NORTH FALLS OFFSHORE WIND FARM

**Appendix H6 to the Natural England Deadline 6 Submission**  
**Natural England's Lesser Black Backed Gull Compensation Site Advice on the**  
**Applicant's Deadline 5 Documents**

Planning Inspectorate Reference EN010119

24 June 2025

Figure 1 Potential LBBG compensation area, Gedgrave Marshes

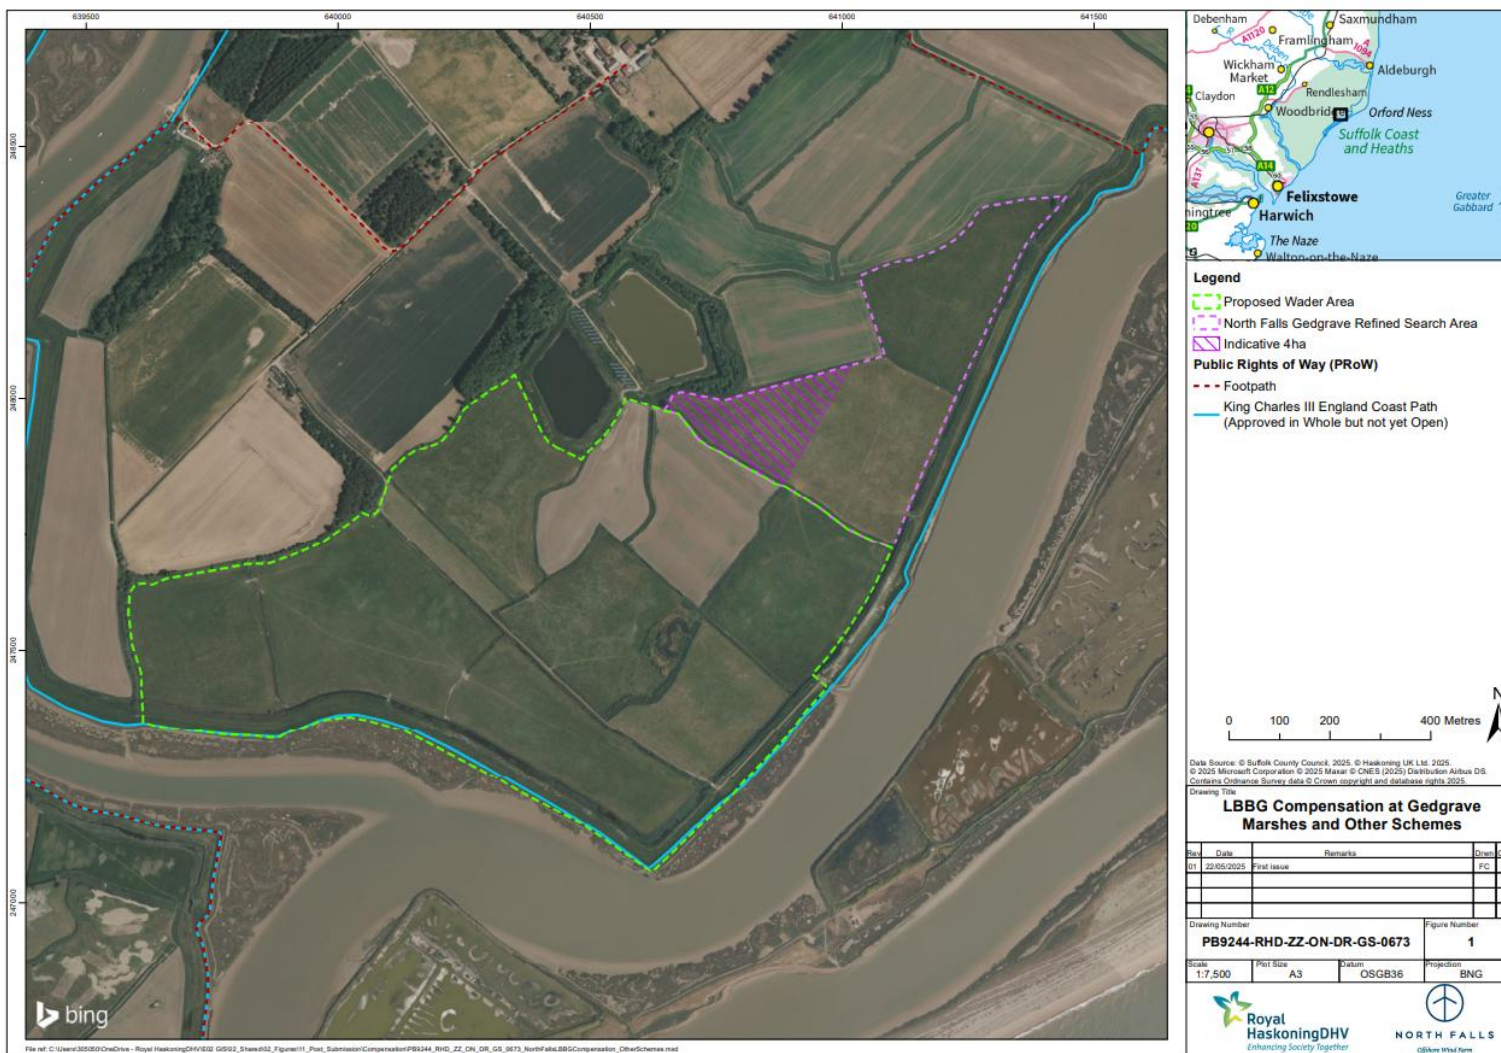
Document reviewed	Update made	Issue resolved?
9.84 HRA LBBG Comp - Gedgrave... (Rev 0)	The HRA assesses impacts on Gedgrave Marshes. This is based on a November 2024 site visit and desk-based information. Conclusions of no Likely Significant Effect (LSE) or Adverse Effect on Integrity (AEol) are based on a precautionary approach considering the site is functionally linked to the SPA/Ramsar bird features. Therefore, we consider that whilst this is not an evidence-based conclusion, the impact assessment does assume that the area is functionally linked for construction, maintenance, and monitoring. In addition, [REP- 064_b] in doc [REP5-055 9.69] confirms that baseline surveys will be undertaken post consent/pre-construction.	Progressed

9.84 HRA LBBG Comp - Gedgrave... (Rev 0)	We note that Paragraph 22 confirms that annual habitat management is anticipated to take place outside of the breeding season, and that installation and maintenance of the fence (taking approx. 2 months) will be carried out between September and January. However, the implications of the fence installation and maintenance for the adjacent RSPB Wader Project have not been considered in the assessment. We advise that if installation and maintenance activities could be carried out in September and October (only extending into November if absolutely necessary) then this would avoid the most sensitive periods for overwintering as well as breeding species.	No
